From: Amanda Scholes on behalf of Planning.Responses
Sent: 22 December 2020 10:19
To: Planning Scanning
Subject: FW: Y/140/20/DOC - Cinders Lane Nursery and works to the rear, Cinders Lane, Yapton, BN18 0JJ

From: Kate Giddings <kate.giddings@arun.gov.uk>
Sent: 21 December 2020 17:59
To: Simon Davis <Simon.Davis@arun.gov.uk>
Cc: Planning.Responses <Planning.Responses@arun.gov.uk>
Subject: FW: Y/140/20/DOC - Cinders Lane Nursery and works to the rear, Cinders Lane, Yapton, BN18 0JJ

In relation to the above address, EH is not able to provide comment on the discharge of conditions 6 (contaminated land) until the Preliminary Site Investigation Report by Soils Ltd. (ref.: 18115/DS, dated February 2020) has been provided for review.

Scale : 1:500 @ A1 Date : SEPT 2020
Drawing No : 97_17_103

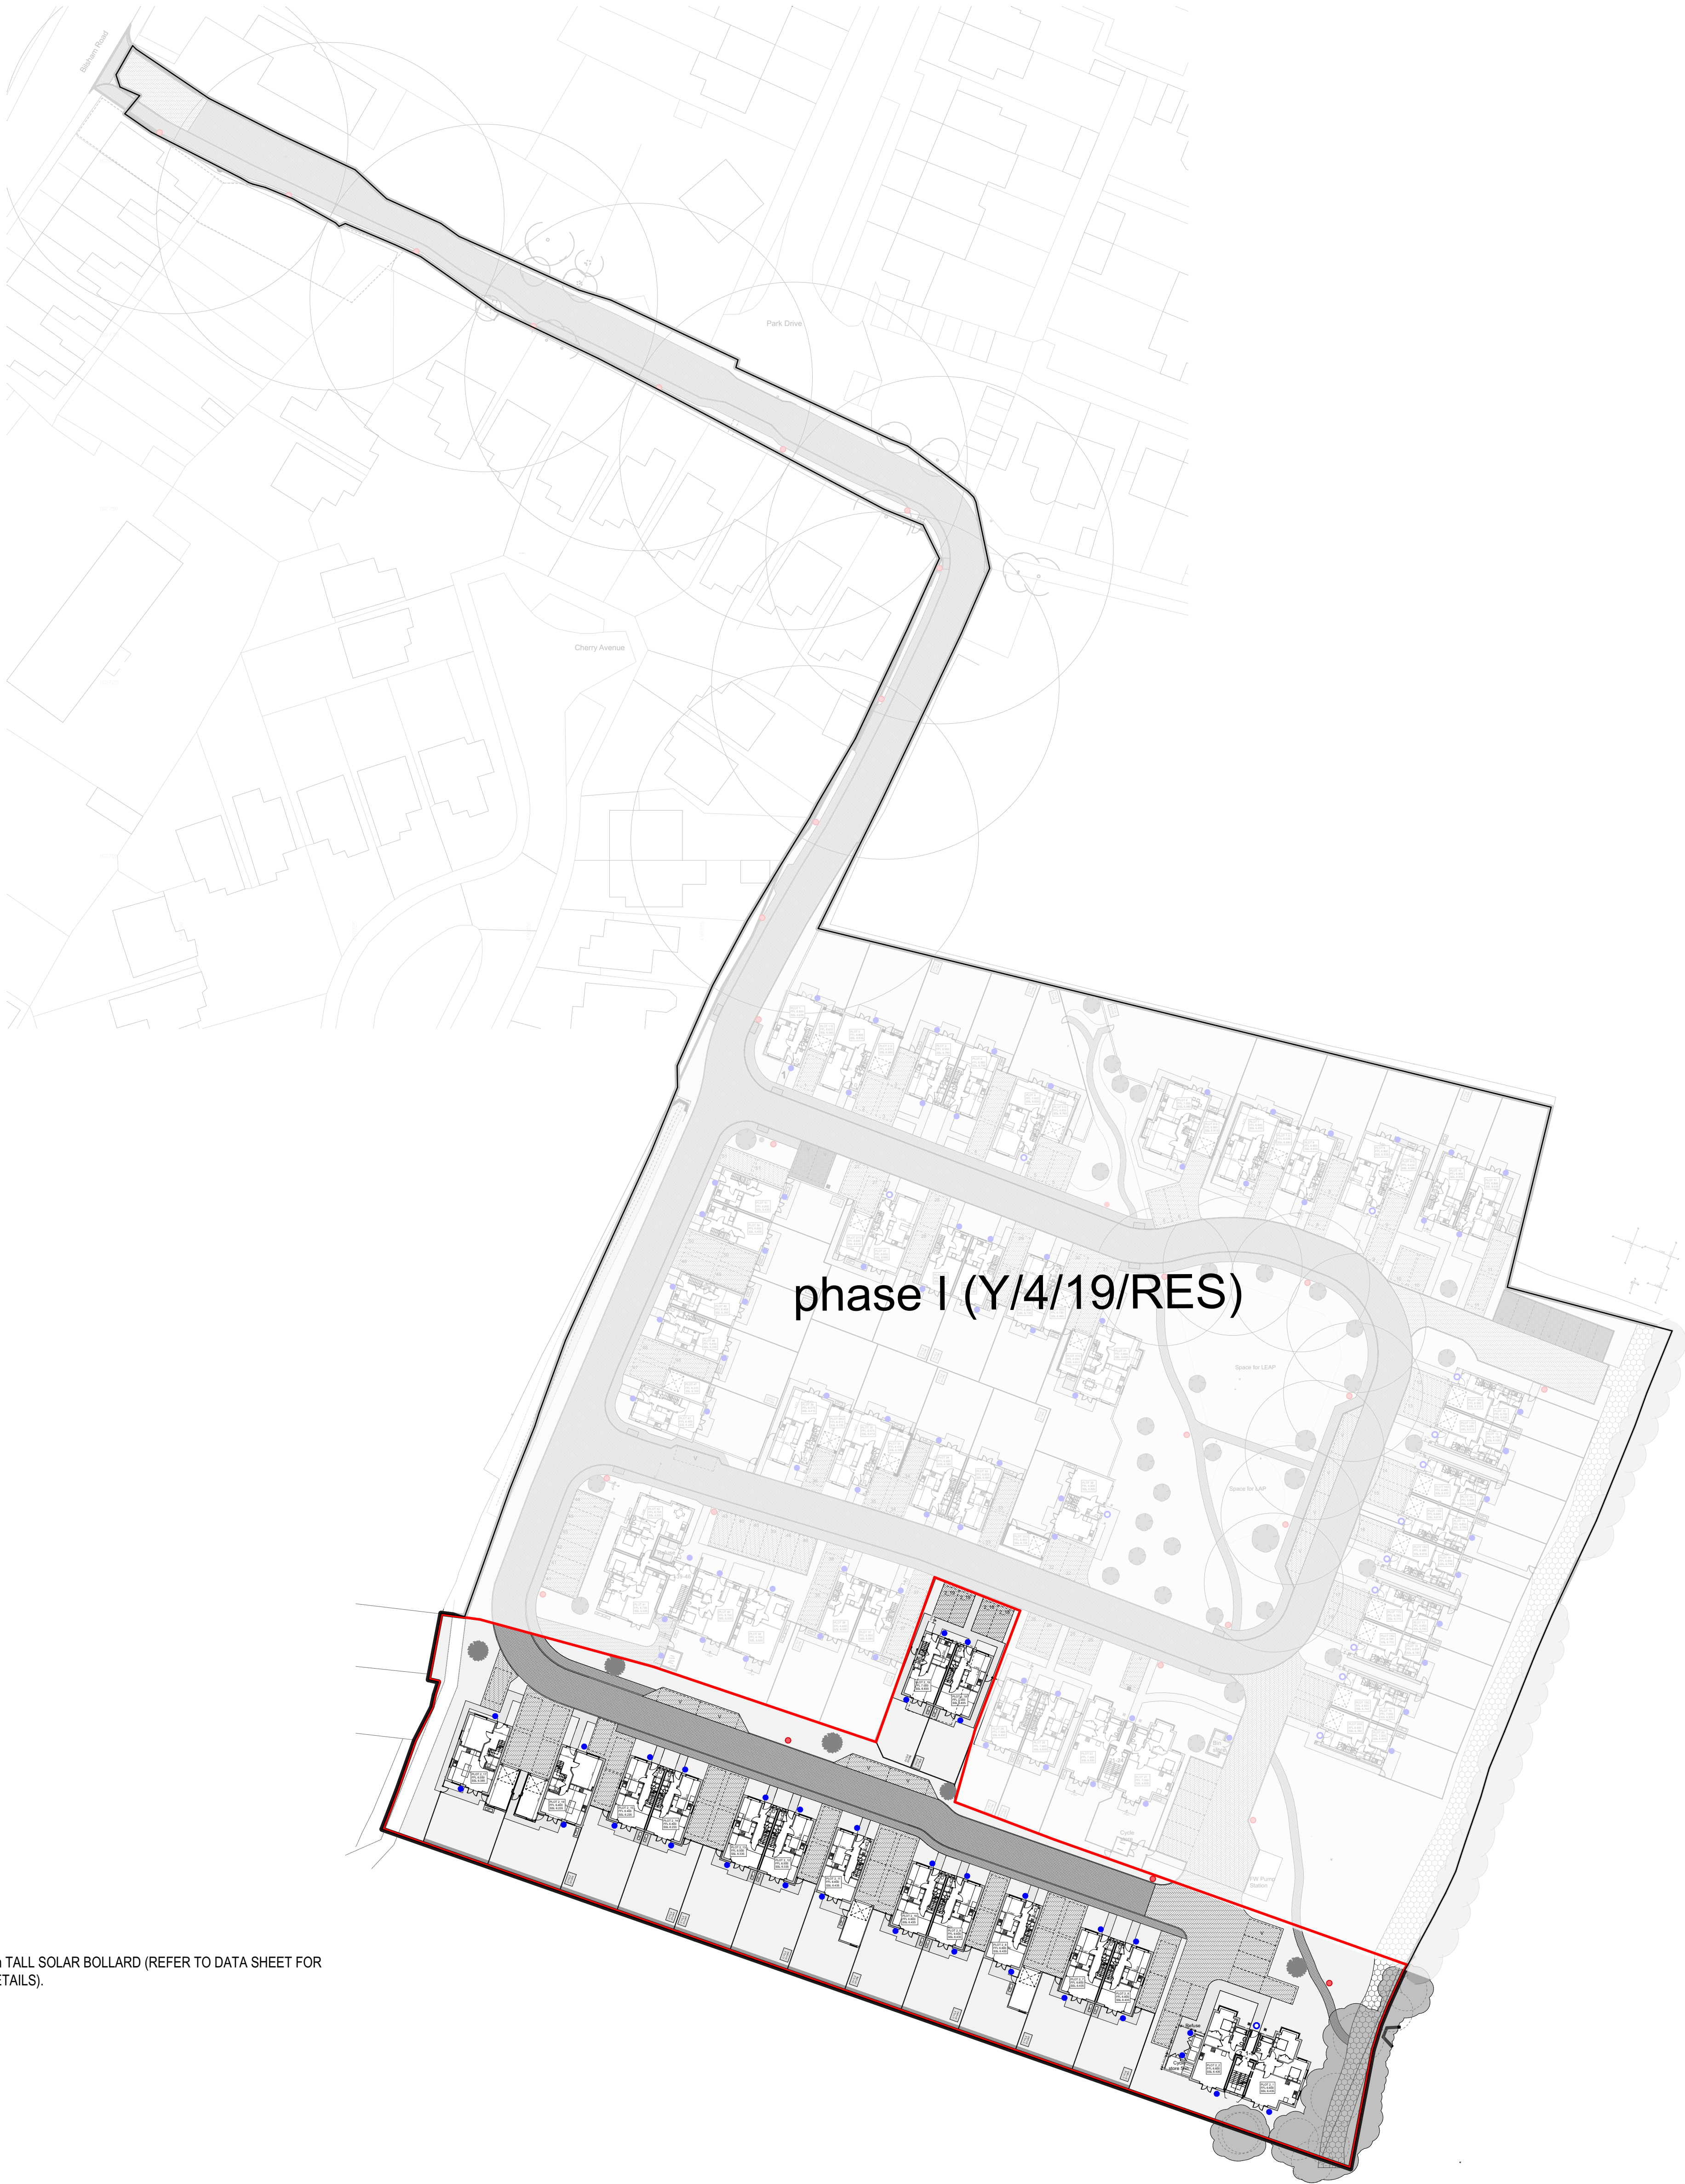
With regard to the discharge of condition 19 (lighting), the external lighting plan and light detail sheets should please be updated to include detail the light spill from each installation point. Please also note that EH cannot comment on the potential impact on bats in the vicinity.
